# TRANSPORT AND ACCESSIBILITY IMPACT ASSESSMENT

**TAFE NSW Construction Centre of Excellence  
Nepean Kingswood Campus – 2-44 O’Connell Street, Kingswood**

Reference: 20.456r02v08  
Date: May 2021

Notes:

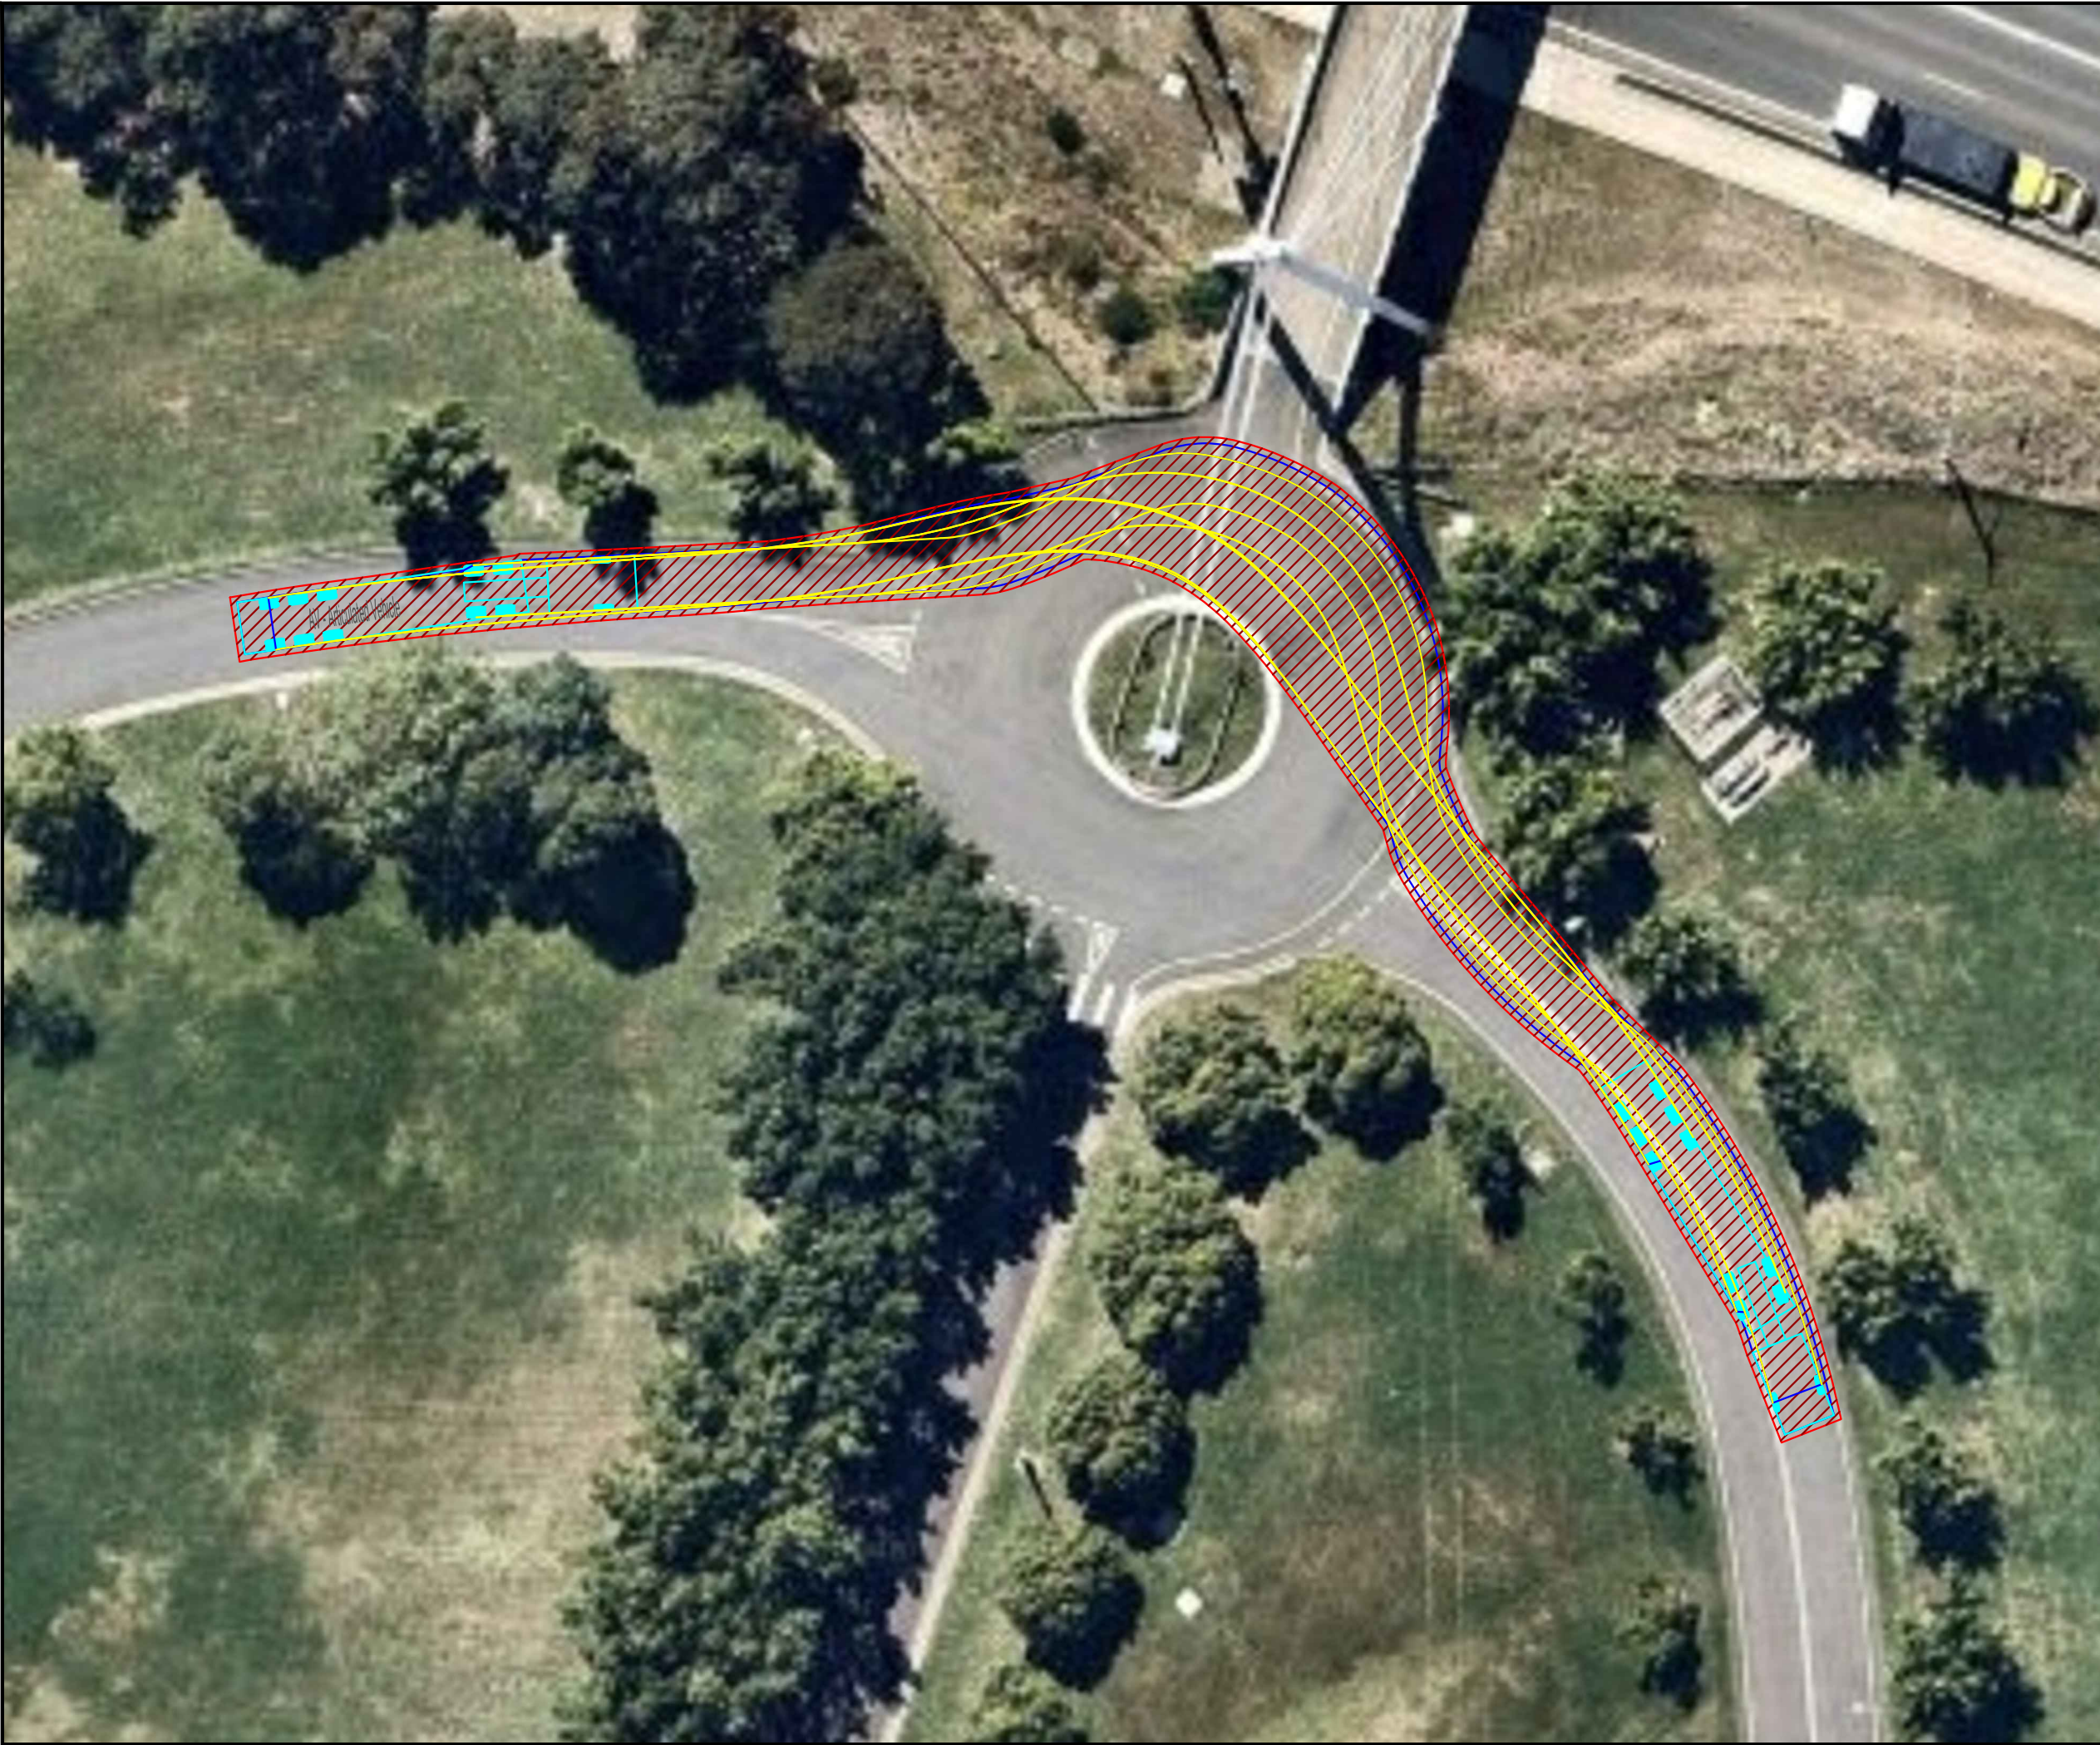
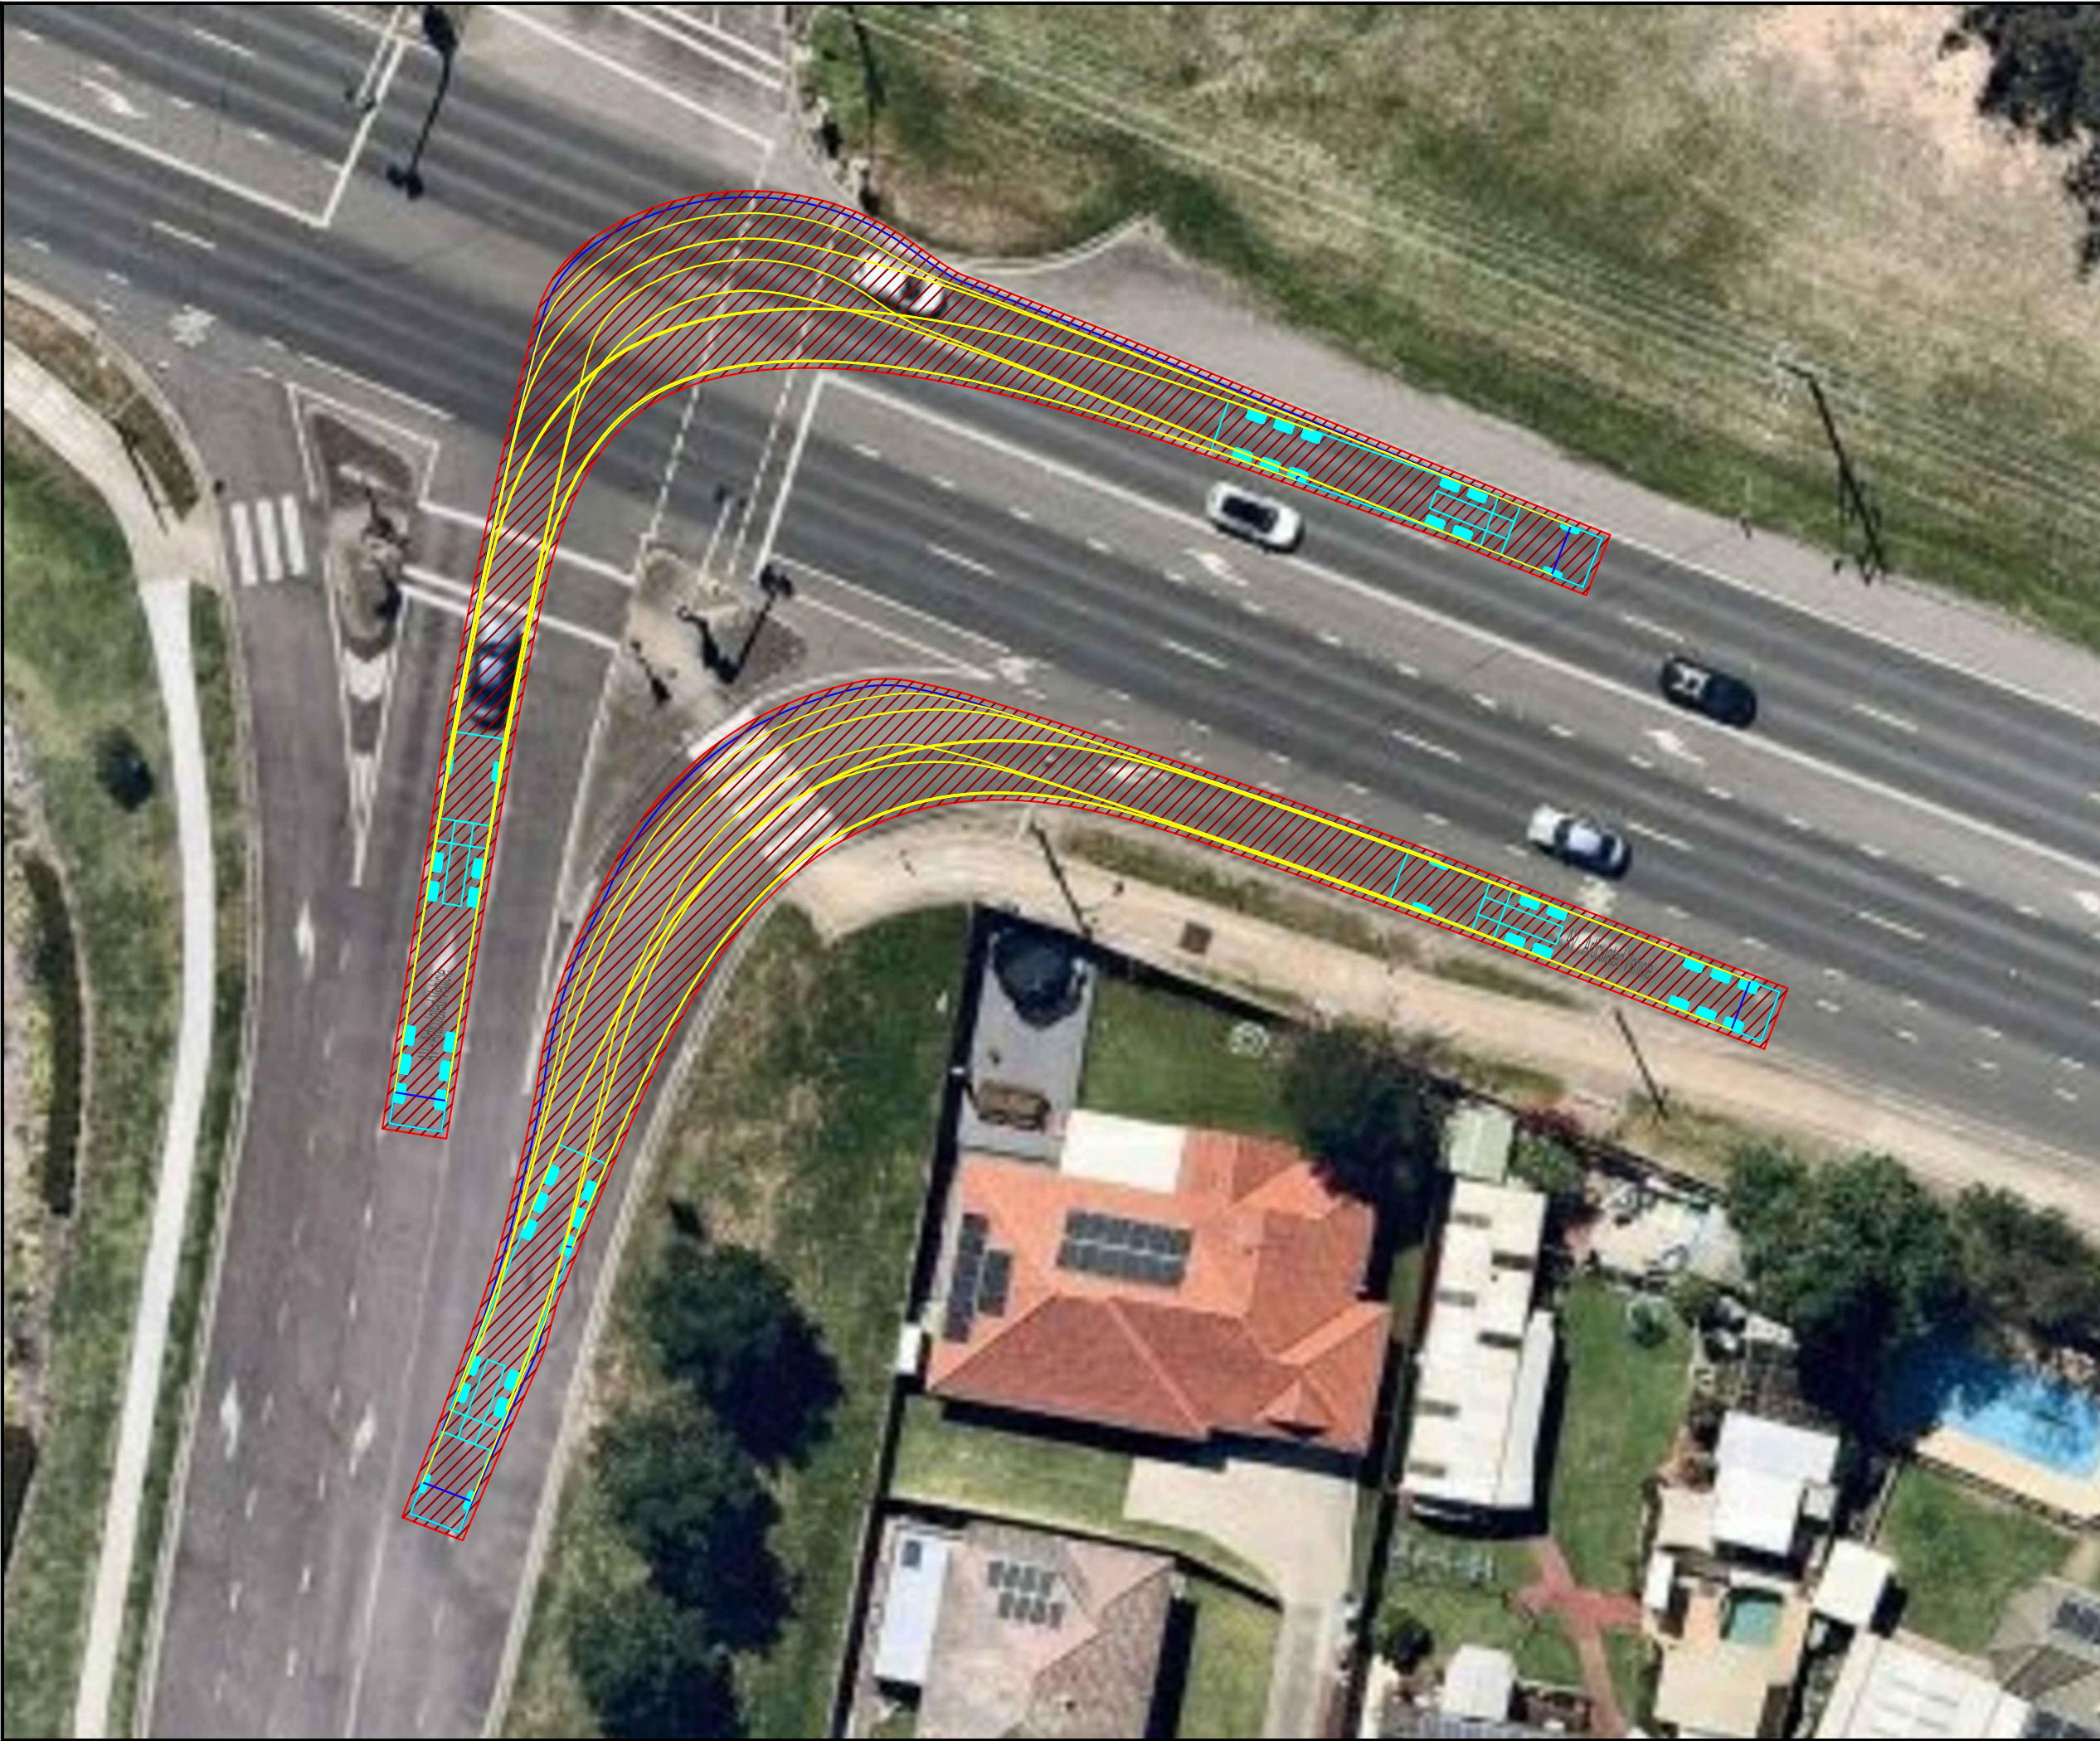
*b. Appendix C Loading Zone Swept Paths: Traffic Controller is recommended to ensure there is no conflict between construction trucks and vehicles / pedestrians using the carpark.*

**TRAFFIX Response:** Appendix C Loading Zone swept path has been updated to include a traffic controller. It is noted that this is a Preliminary CTPMP and further details of traffic controllers will be provided within the detailed CTPMP and final TCPs.
